From: Connor Armi <connor.armi.hsy@colvilletribes.com>
Sent: Thursday, January 23, 2025 1:00 PM
To: Bradley Gasawski
Cc: Guy Moura; sepa@dahp.wa.gov
Subject: Re: SP-25-00001 Graf - Notice of Application

RE: SP-25-00001

RE: SP-25-00001 Graf Short Plat – City of Ellensburg Comments (File # EX25-001)

TO: All Staff
FROM: Public Works Plan Review Team
DATE: February 3, 2025
SUBJECT: SP-25-00001 Graf

GRAF SHORT PLAT

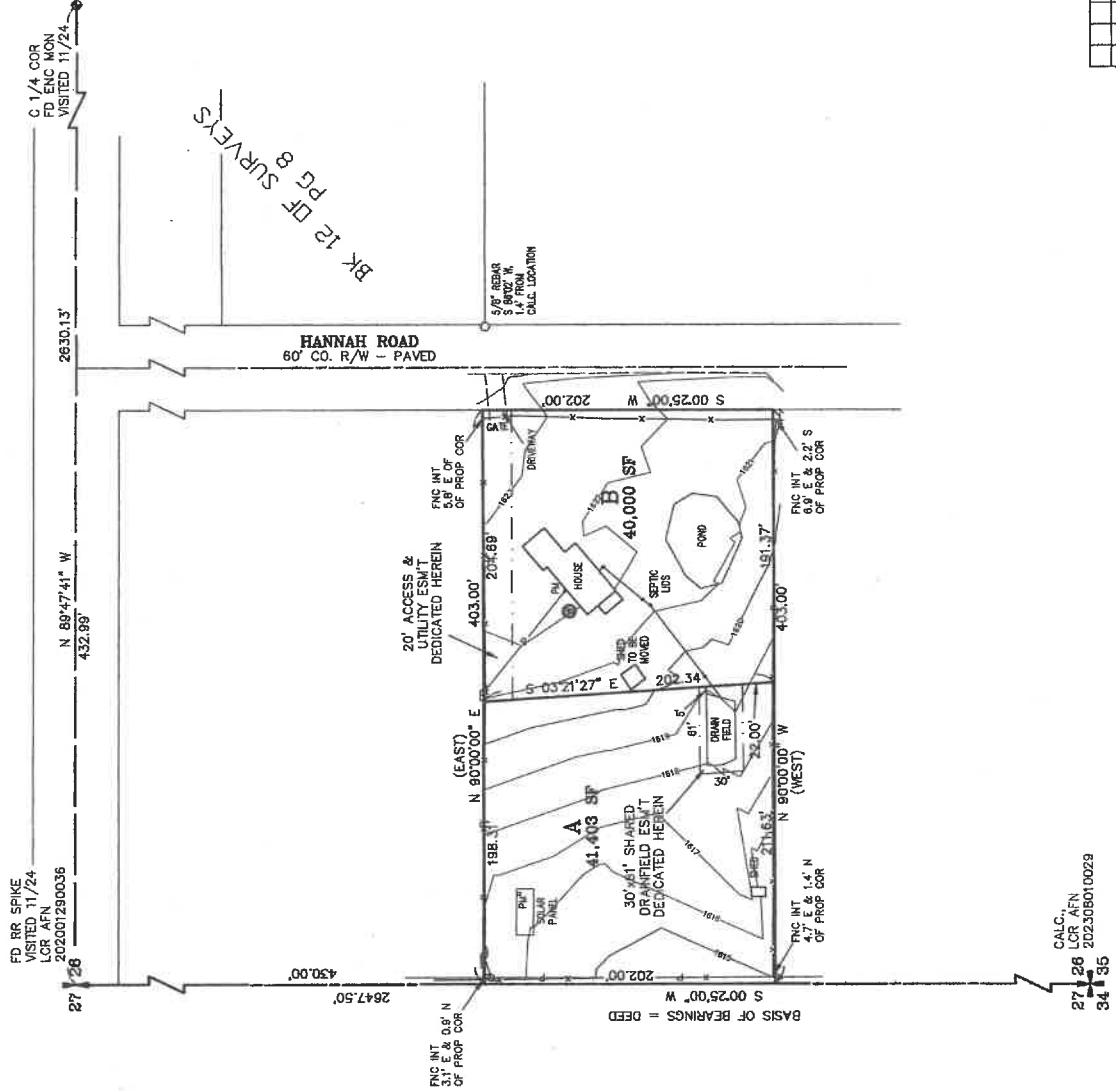
The proposed plat split of 841133, a 1.87-acre plat, into two plats, one measuring 41,403 square feet and the other 40,000 square feet, with existing septic and well systems, cannot be approved at this time due to current regulatory requirements. The primary issue is that the proposed plats do not meet the minimum land area requirements for developments with individual wells, as outlined in Washington Administrative Code (WAC) 246-272A-0320.

Septic system is not permitted for use because a recorded drawing (as-built) has never been submitted.

COE Light Dept. Requires a 10ft utility easement along Hannah Road. Contact the County PUD if they require a 10ft easement for their pole lines on lot "A". It may be in the applicant's interest to provide an easement for the solar panels and its equipment if they are to continue to provide power to lot "B".

Ellensburg Planning noted solar panels on proposed Lot A, presumably providing power to the residence on proposed Lot B. Applicant may wish to consider recording a private easement for these panels and its electrical service that crosses lot boundaries on the face of the plat.

The site plan provided appears to show a corner of an existing shed on the proposed parcel boundary line. The note states "Shed to be moved." The shed would need to be moved prior to the short plat to remain compliant with the Fire Separation requirements of the Washington State International Residential code. Additionally, if the shed is over 200 square feet and/ or contains any habitable space, mechanical systems or plumbing, a building permit would be required to relocate the structure.

SURVEY	<ol style="list-style-type: none">1. As the Prelim Short Plat shows elevations, it will need to meet the requirements of WAC 332-130-145. <p>The following reflect changes that will need to be shown on the final Short Plat:</p> <ol style="list-style-type: none">2. The Basis of Bearing should refer to a document of record for the Deed. (EX: Basis of Bearing=Deed (AFN:12345))3. Label Bender Road (label only, width and surfacing not required)4. Set and show property corners.
TRANSPORTATION CONCURRENCY	No transportation concurrency requirement for this project. (KAH)
FLOOD	Parcel #841133 is not mapped within the FEMA identified special flood hazard area (100-year floodplain). A floodplain development permit is not required for the proposed project. (SC)

CITY OF ELLENSBURG
NATURAL GAS DIVISION
UTILITY MAP REQUEST INFORMATION

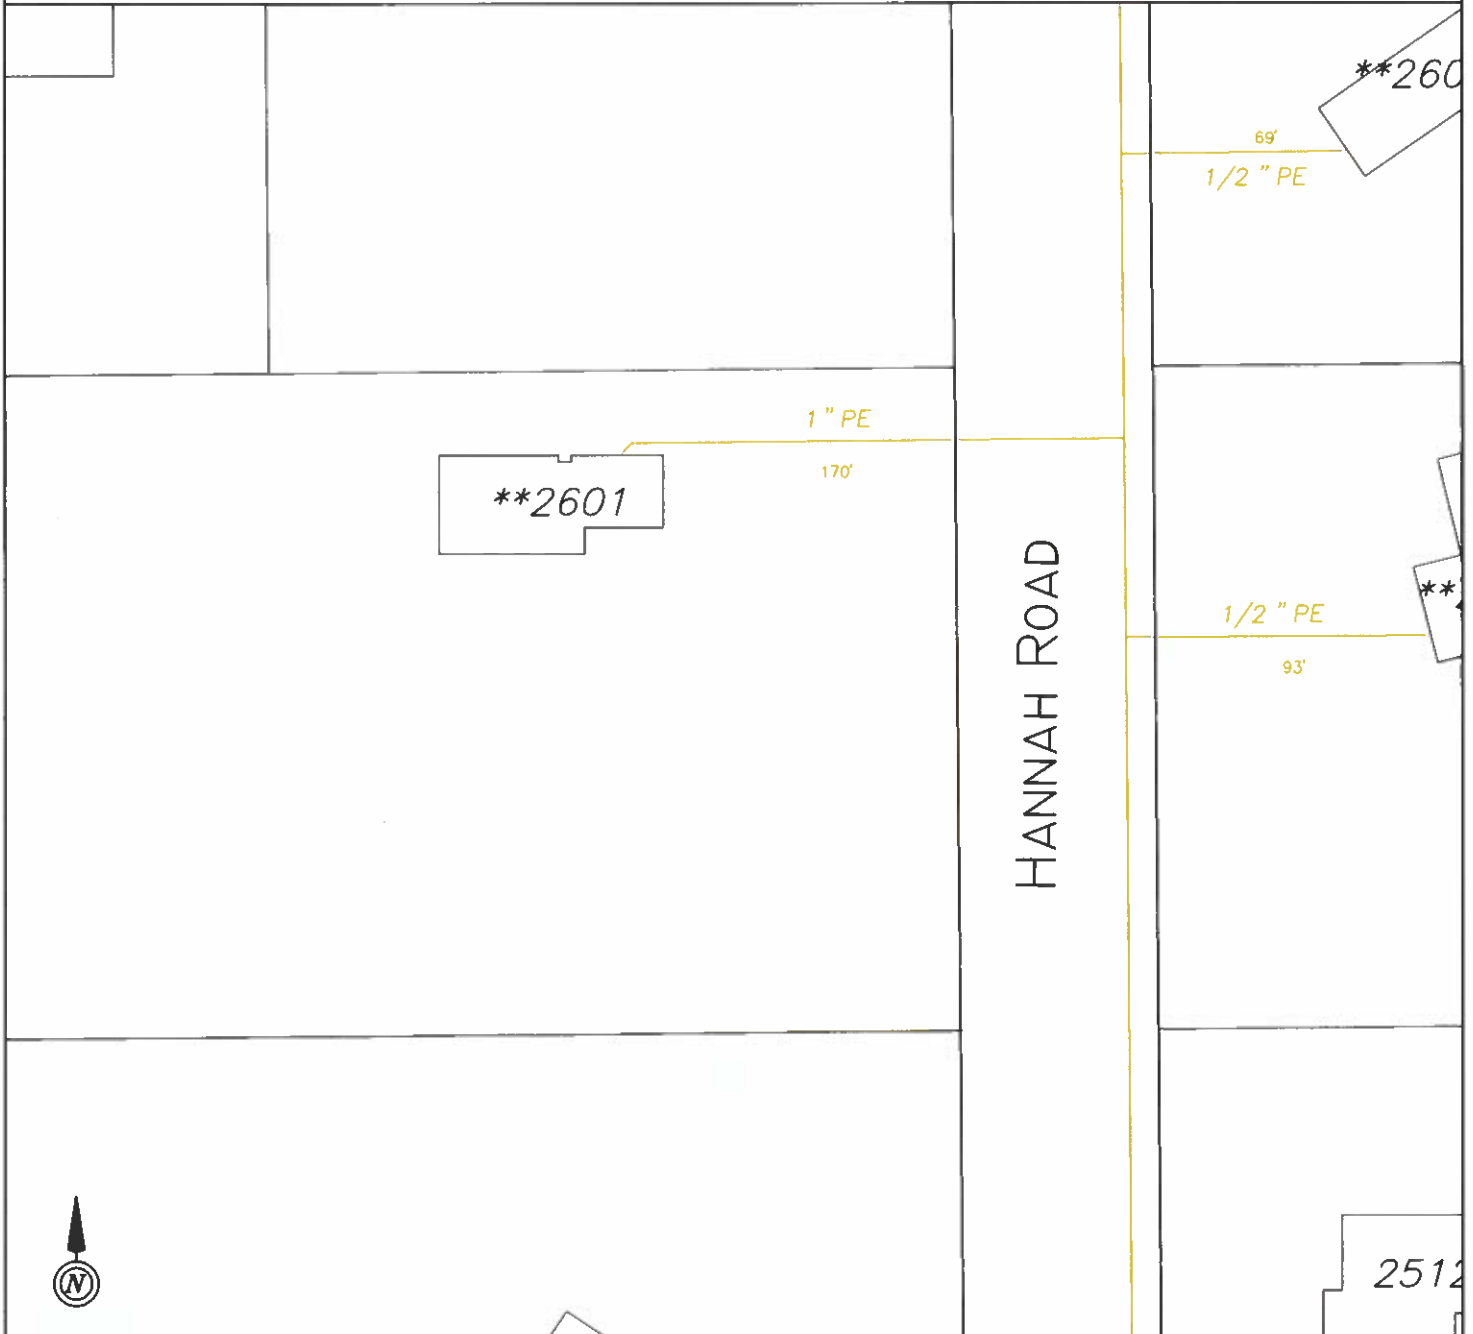
There is a natural gas utility map attached showing the existing infrastructure in the vicinity of the proposed project. The existing residence has a service line that runs from Hannah Rd to the northeast corner of the residence.
